**KIRKLEES METROPOLITAN COUNCIL
INVESTMENT & REGENERATION SERVICE**

**DELEGATED DECISION TO DETERMINE APPLICATIONS FOR
NON-MATERIAL AMENDMENTS**

Reference No: 2018/NM/93928/W

Site Address: 176, Laund Road, Salendine Nook, Huddersfield, HD3
3TY

Rear Elevation as Amended

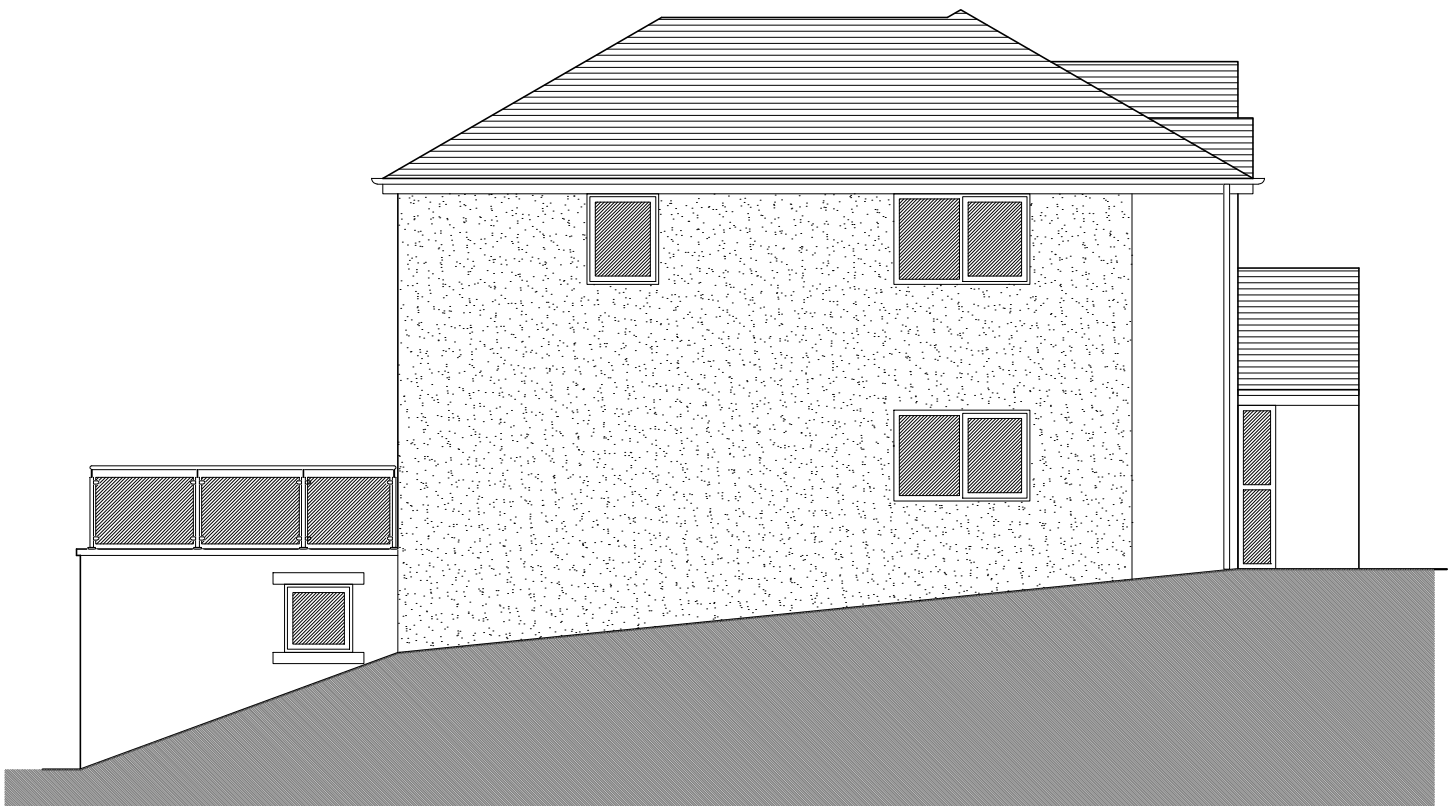
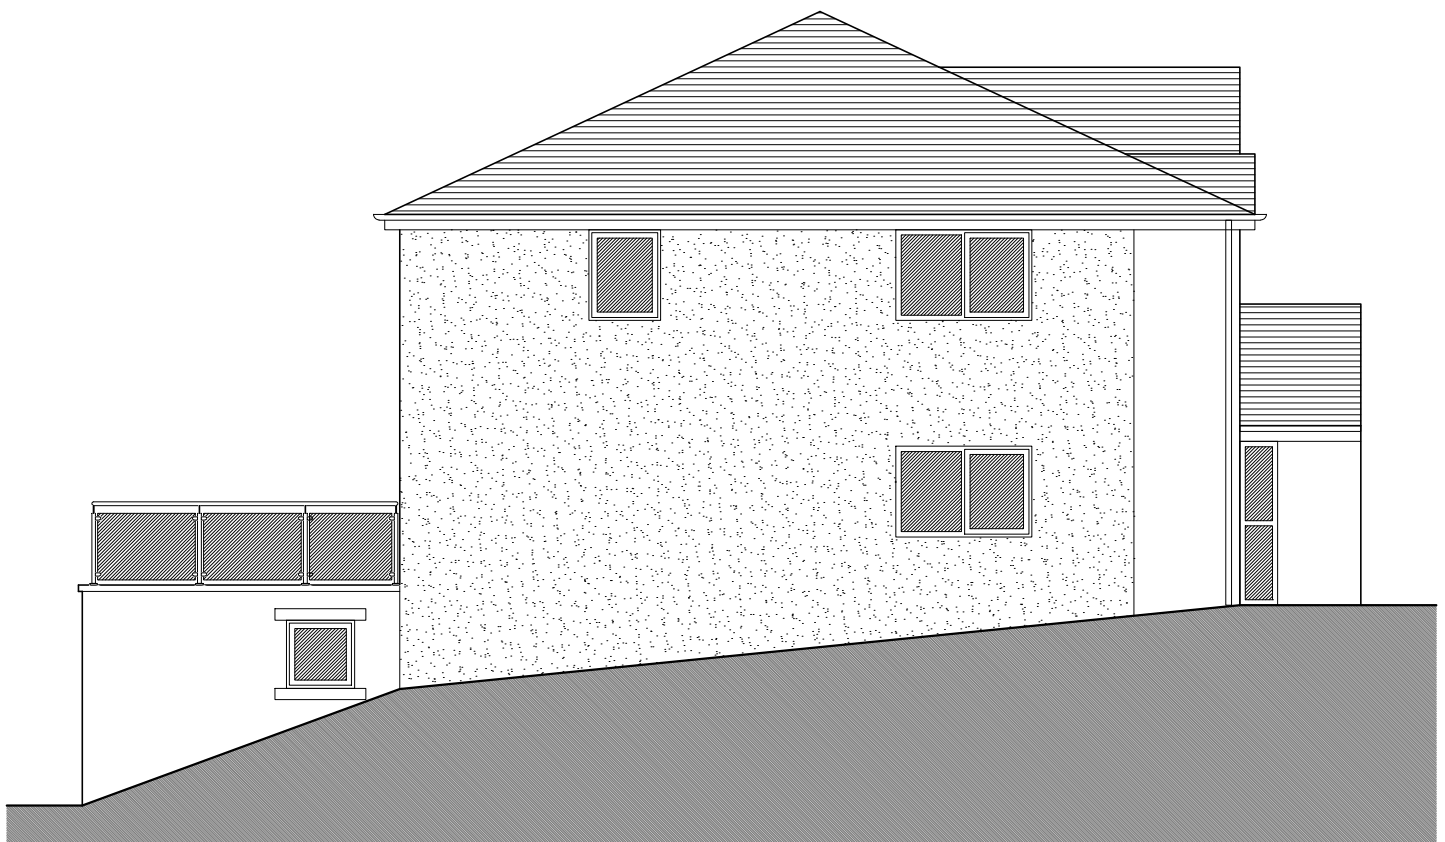
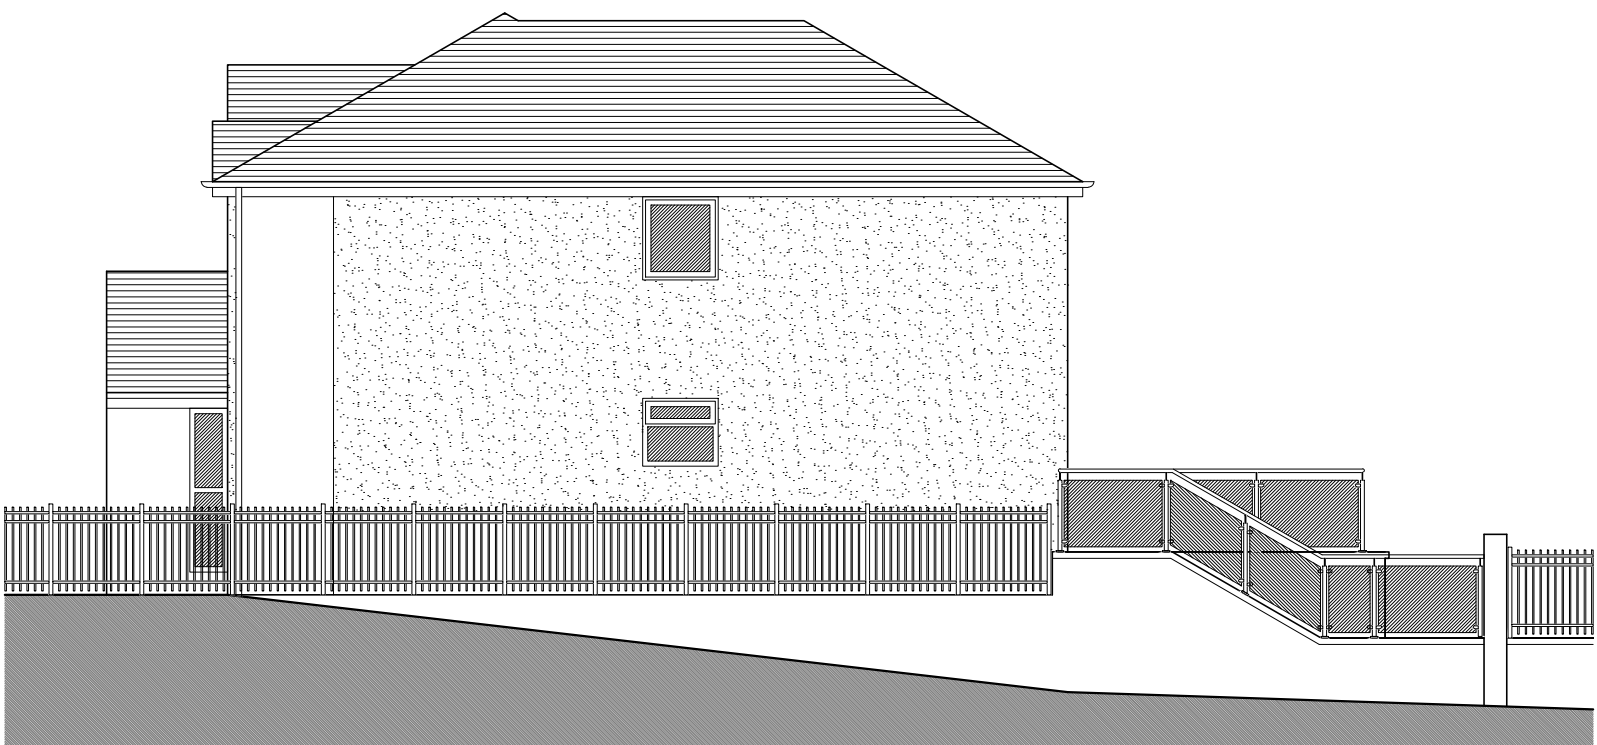
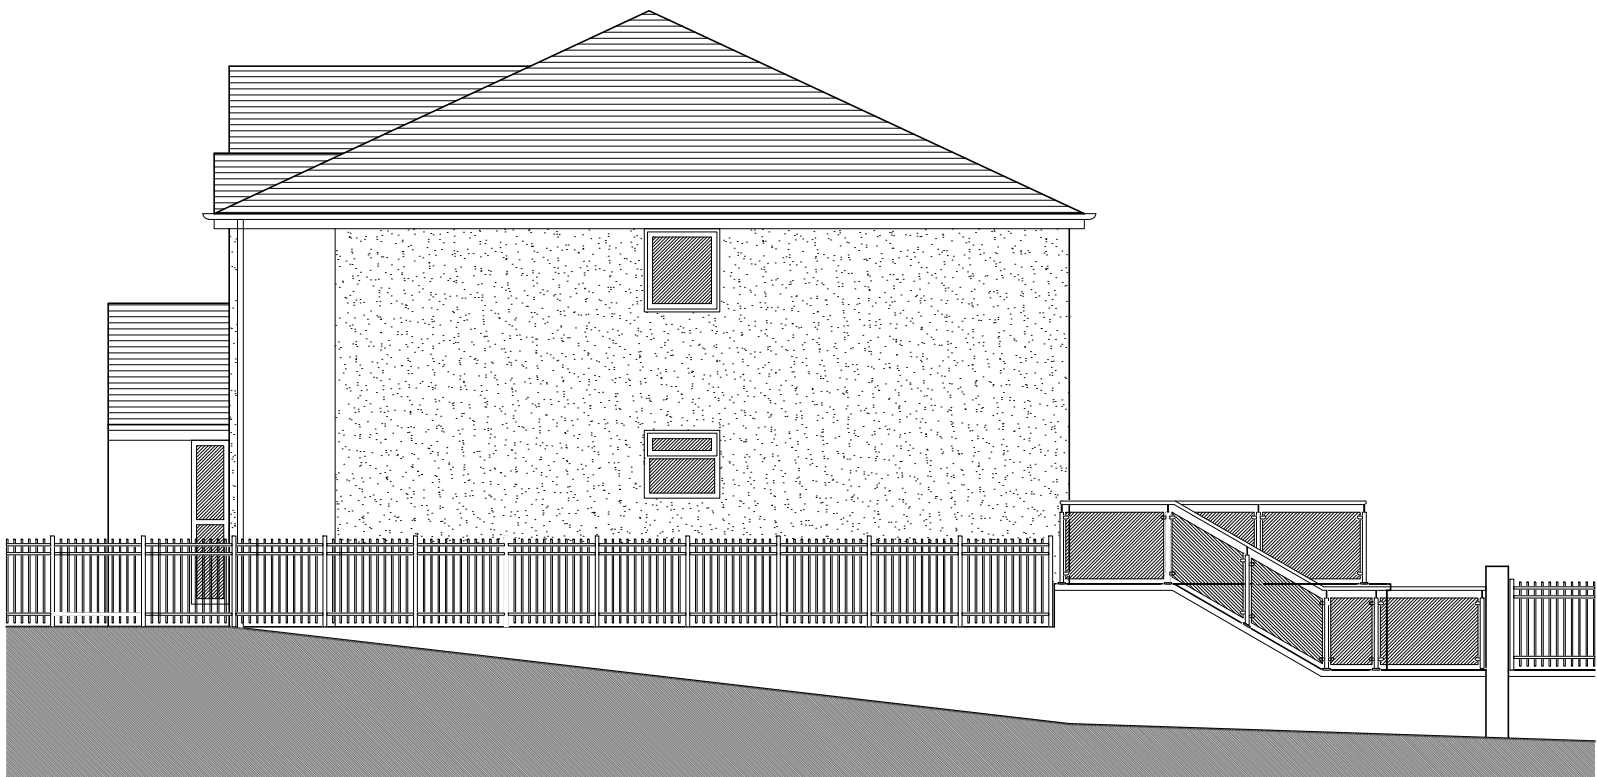
The amendment relates specifically to the roof form of the development and the removal of the double hipped roof within the rear elevation of the property resulting in a simplified roof form.

In terms of this particular application, the alteration is removal of the double hipped roof within the rear elevation of the property resulting in a simplified roof form.

The amendment sought removal of the double hipped roof within the rear elevation of the property as shown on drawing number NA01 – Proposed plans and elevations and is considered to be acceptable.
